Reference No:	2023/62/92929/W
Site Address:	Park Views, 72, Beaumont Park Road, Beaumont Park, Huddersfield, HD4 5JH
Description:	Erection of outhouse/pergola
Recommending Officer:	Laura Yeadon

DECISION – CONDITIONAL FULL PERMISSION

Officer Report

Project Name 72 Beaumont Park Road, Beaumont Park, Huddersfield, HD4 5JH	
Drawing Title: Proposed Layout-Pergola	
Drawing Number: TR-A23-0903-005	Scale: 1 : 100@A1
Date: 02/10/23	Revision: A
Drawn By: AM	Checked by: JA
Reason For Issue: Planning

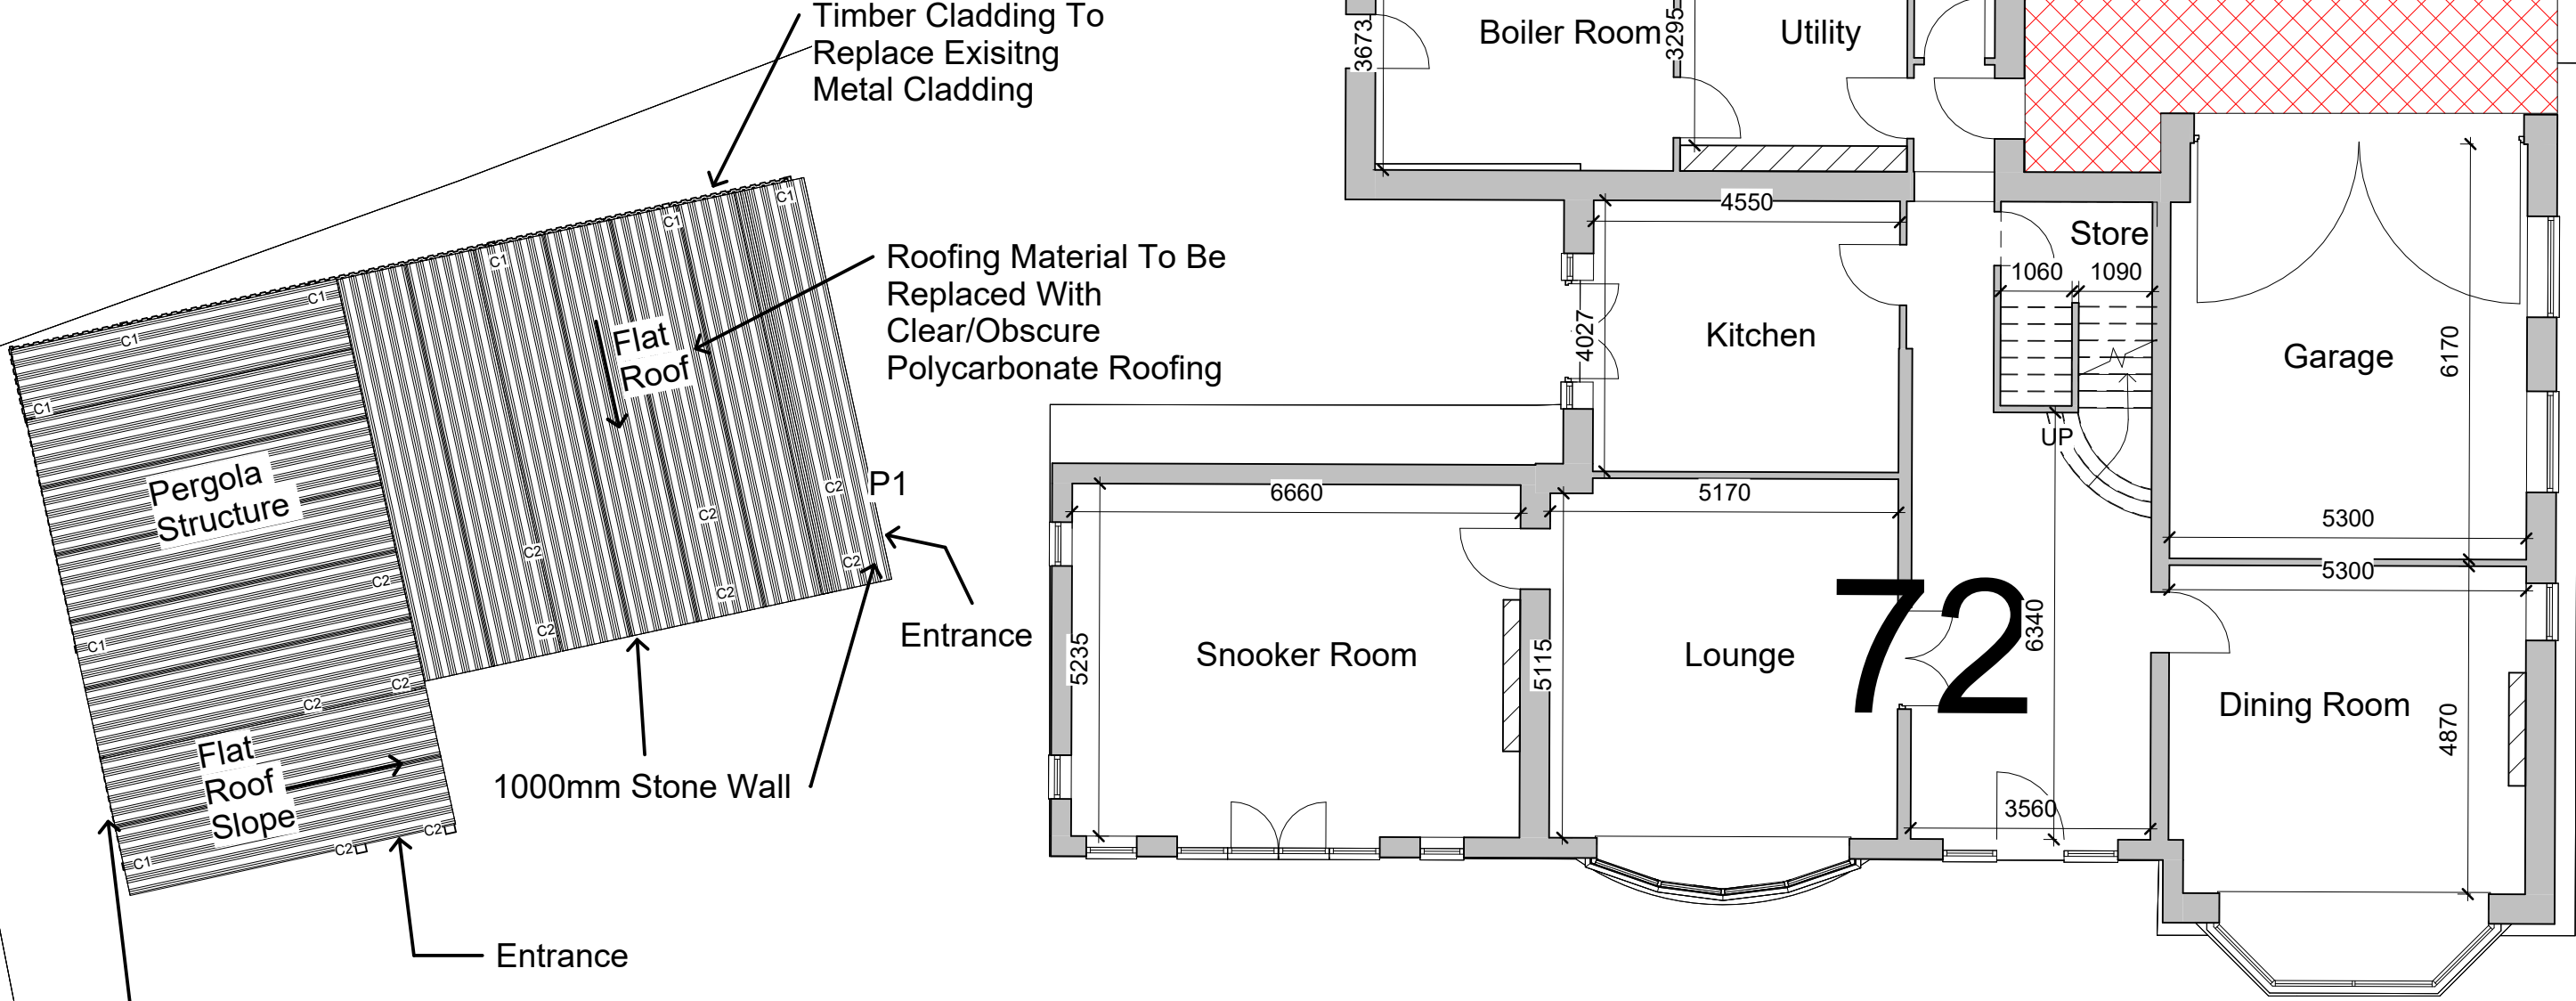
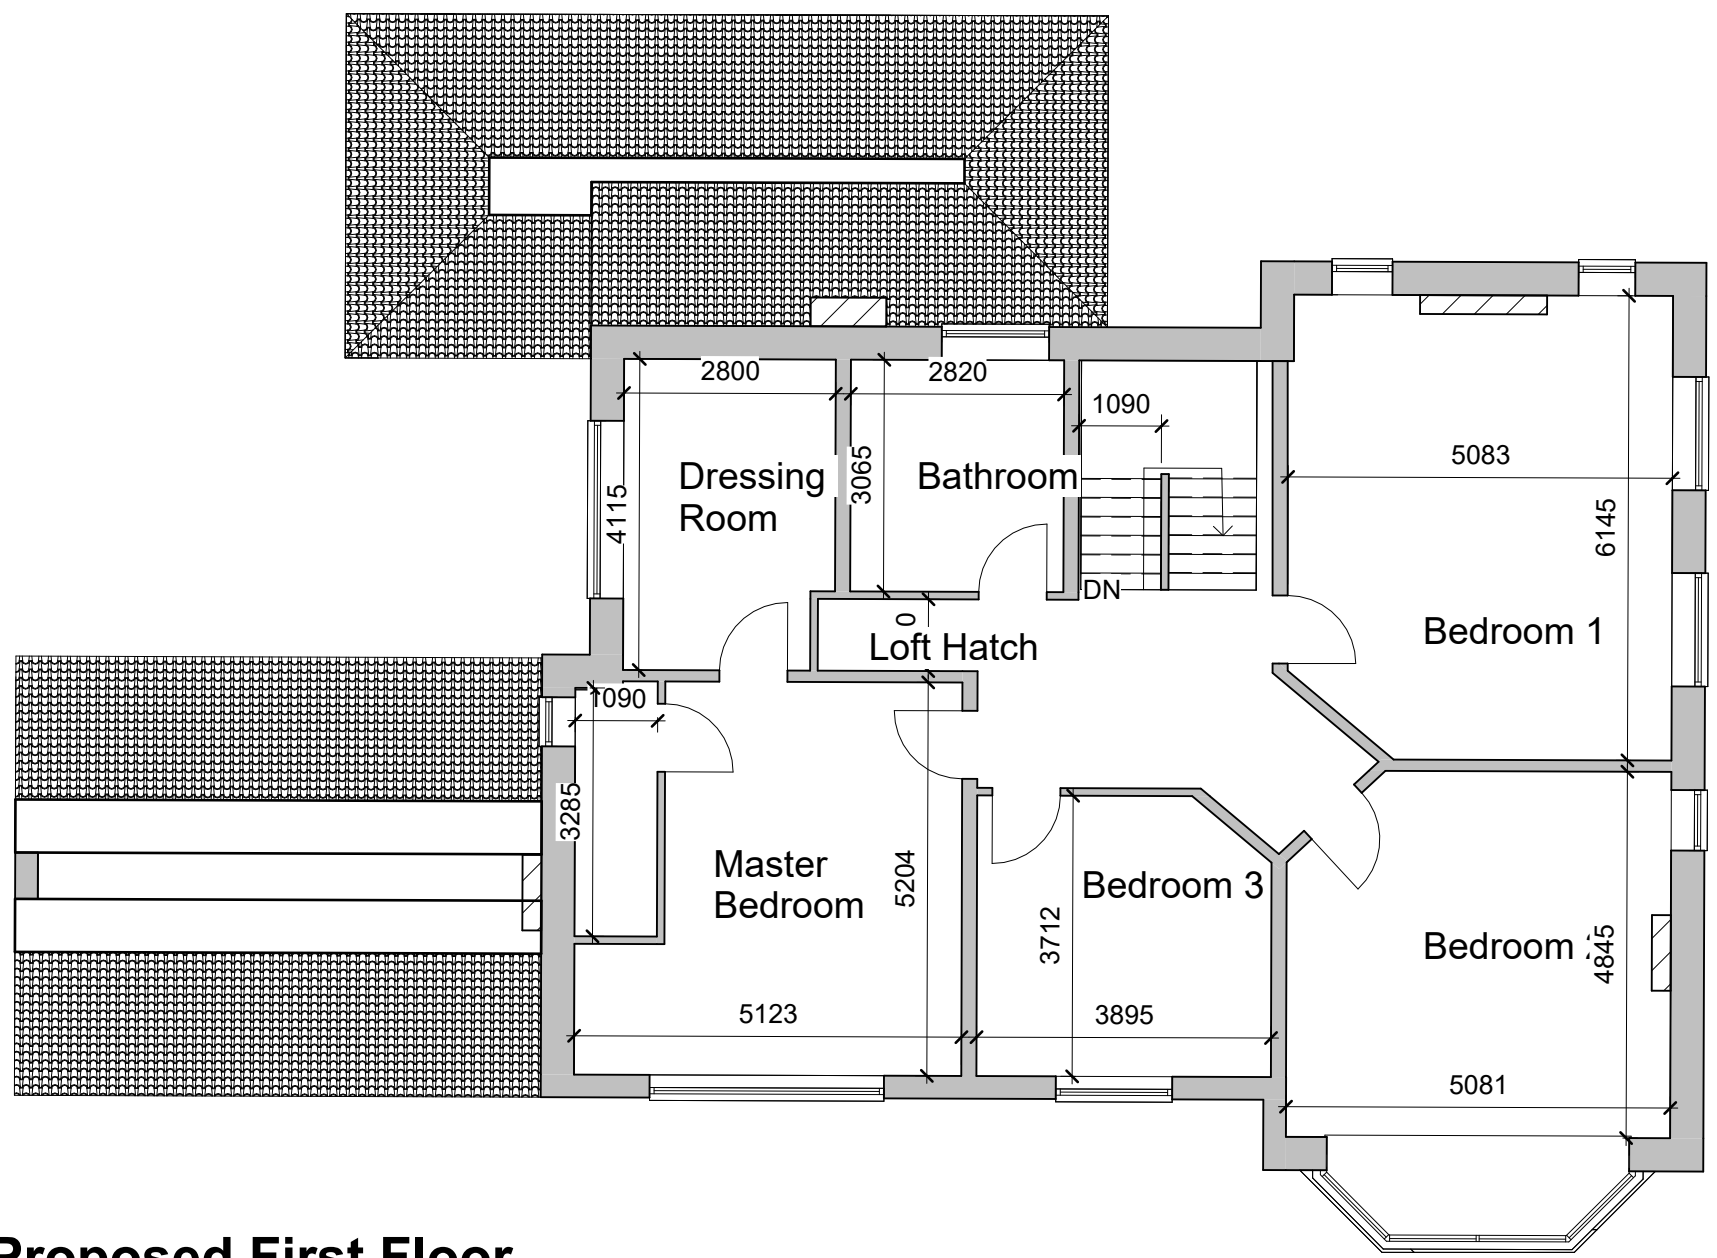
The proposed outhouse/pergola has been significantly reduced on plan from the previous application with the front projecting section being significantly reduced so that the building would mainly sit behind the building line of the front elevation of the property with the corner of the structure marginally projecting forward. It is also proposed that the metal clad walls would be removed and replaced with timber cladding and that the metal roof is removed and replaced with clear/obscure polycarbonate.

The reduction in footprint would be smaller than that of the main dwelling and is, on balance, considered to be subservient having a neutral impact on visual amenity. The structure would be screened from Beaumont Park Road and the wider street scheme is characterised by dwellings set within modest curtilages, set back from the roadside with manicured front gardens. As such, as amended, the building allows for a sufficient level of garden space to remain.

Therefore, other than the front corner of the structure, the works, as demonstrated on plan, would likely not require planning permission.

2. Within three months of the date of this decision the external wall materials of the outhouse/pergola hereby approved shall be finished in timber. The roofing materials shall be finished in clear/obscure polycarbonate. The approved materials for the walls and the roof shall be completed within three months of the date of this decision and thereafter retained for the lifetime of the development.
